HIGHWAY AND LEAD LOCAL FLOOD AUTHORITY RESPONSE TO CONSULTATION ON THE FOLLOWING DEVELOPMENT PROPOSAL

Application number: H11-0755-26

Proposal: Proposed Single Storey Dwelling

Location: Adj. 73 Little London, Long Sutton, Spalding, PE12 9LF

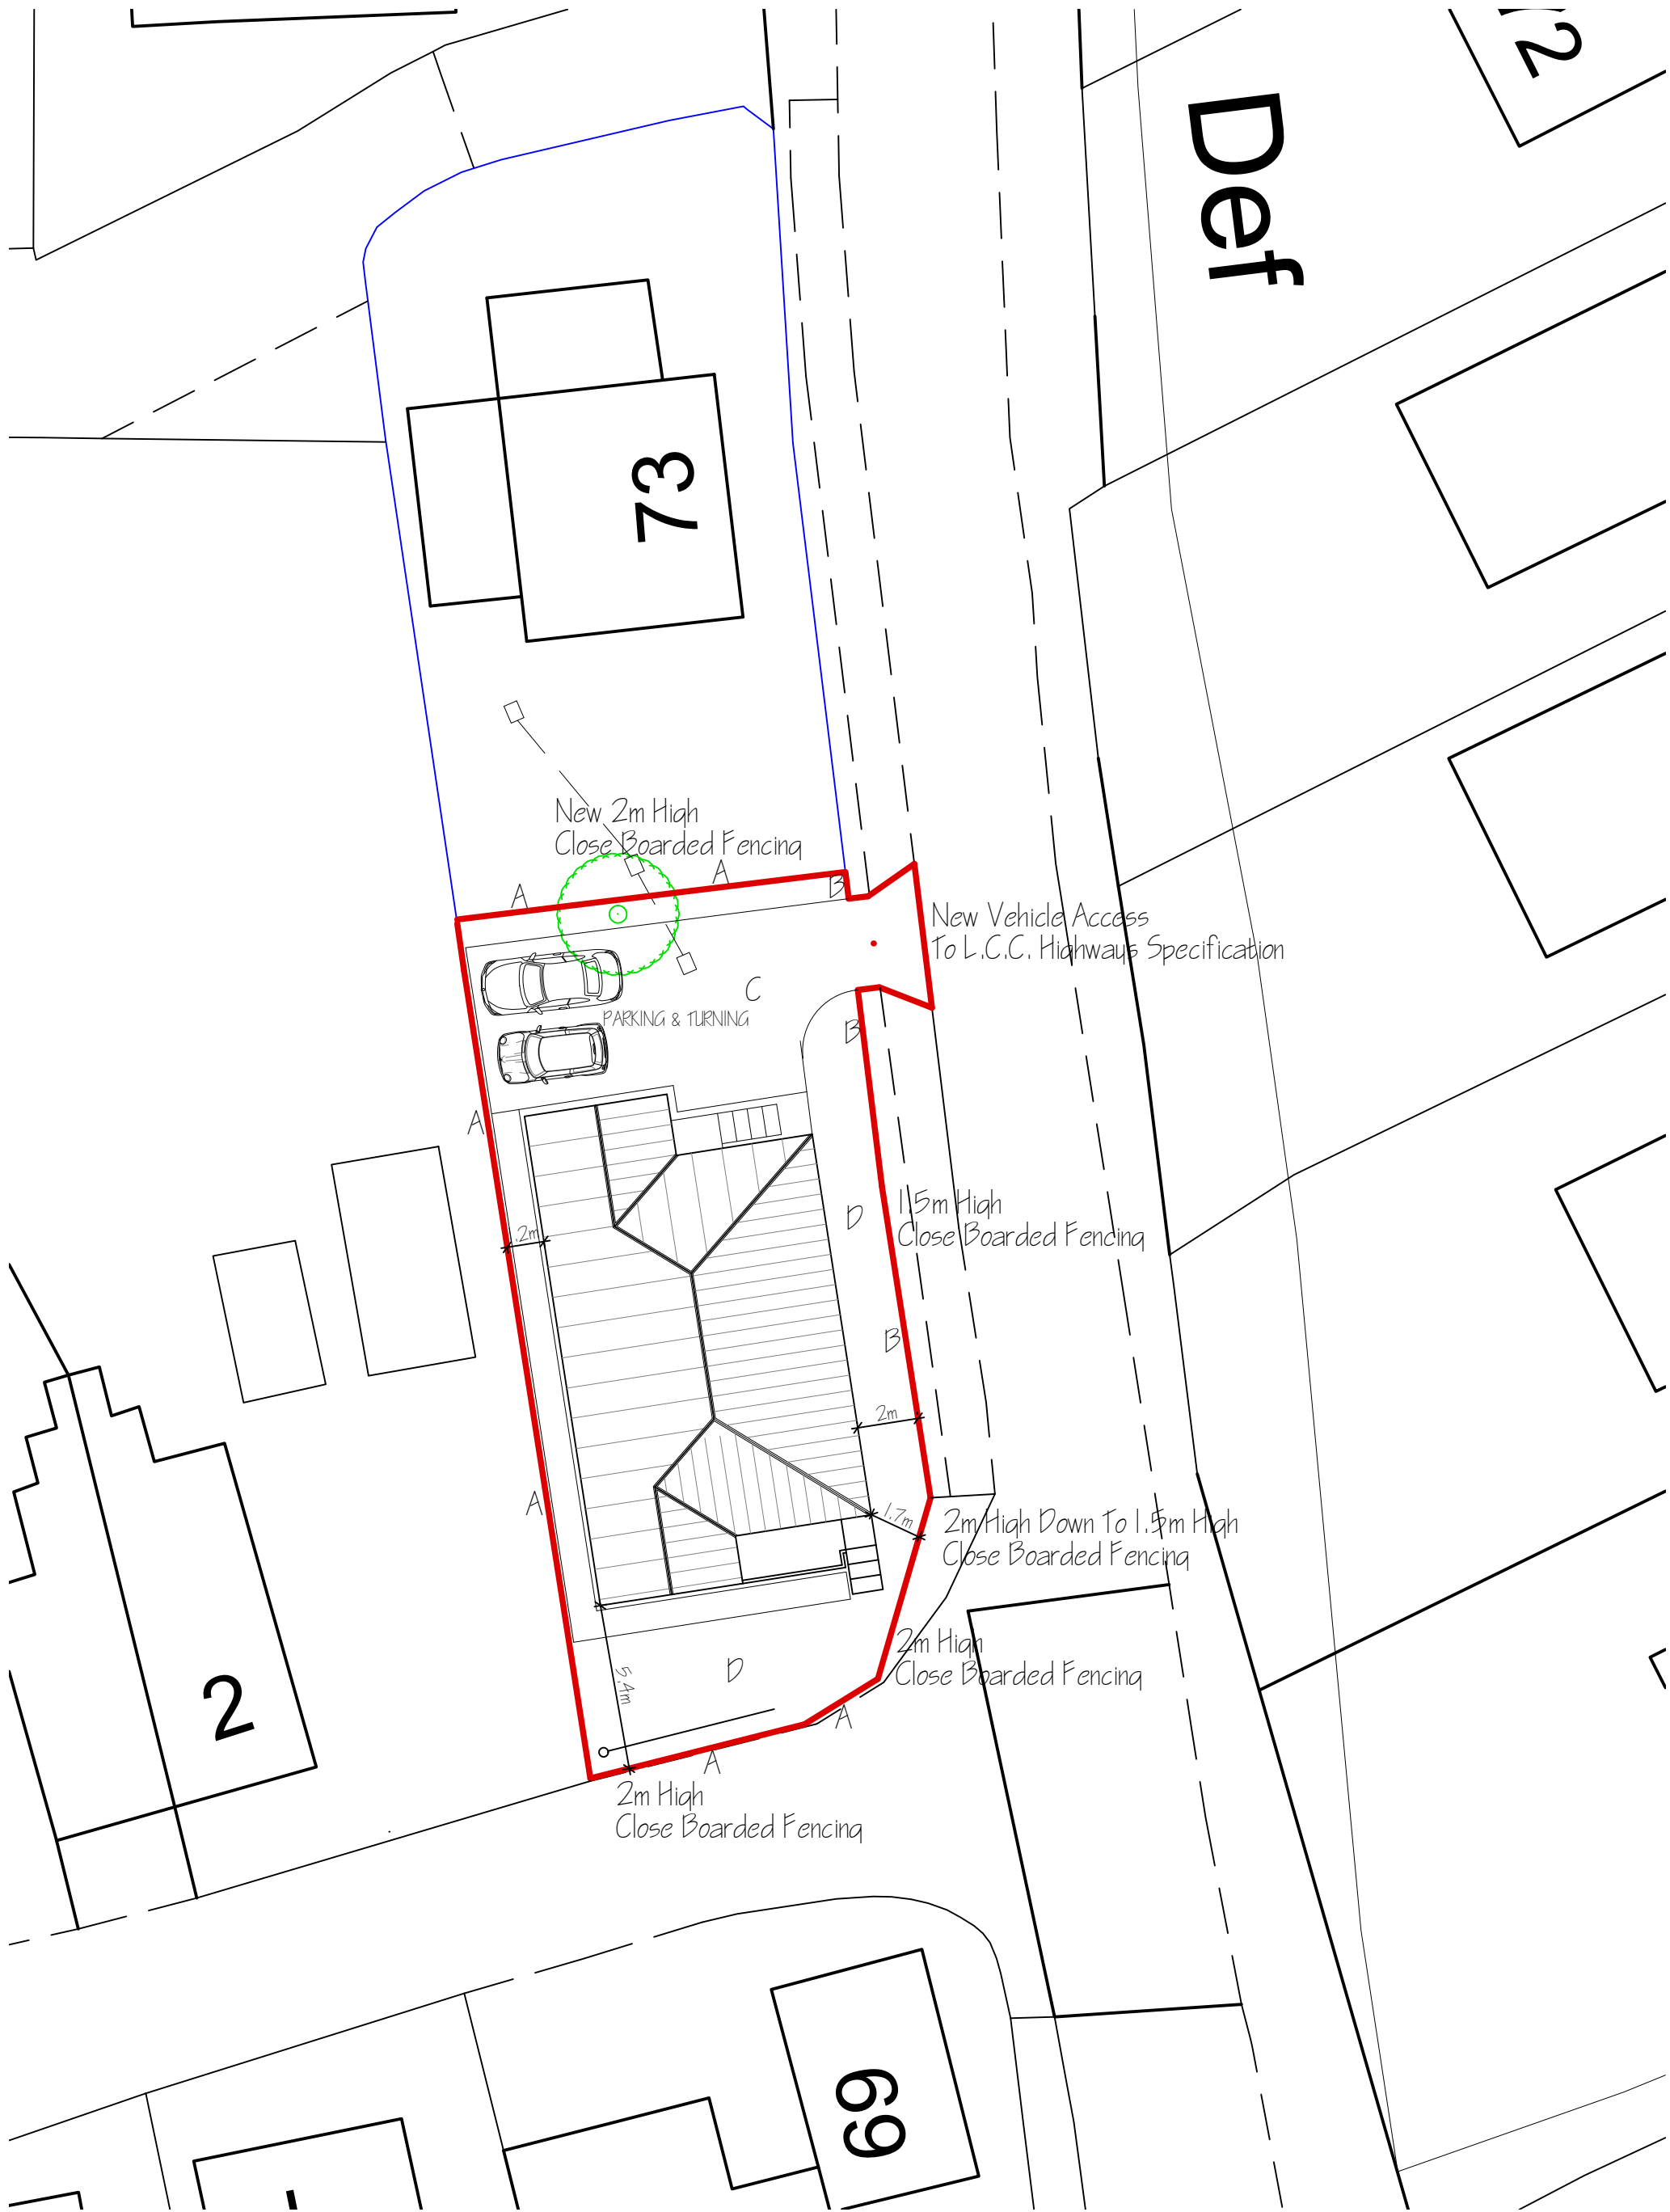
This proposal is for proposed Single Storey Dwelling. The vehicular access meets the visibility guidelines set out in Manual for Streets. The car parking provided is in line with the guidance set out in Lincolnshire County Councils Design Approach and turning space has been provided within the limits of the site to allow vehicles to enter and leave in a forward gear and therefore, it is considered that this proposal would not result in an unacceptable impact upon highway safety.
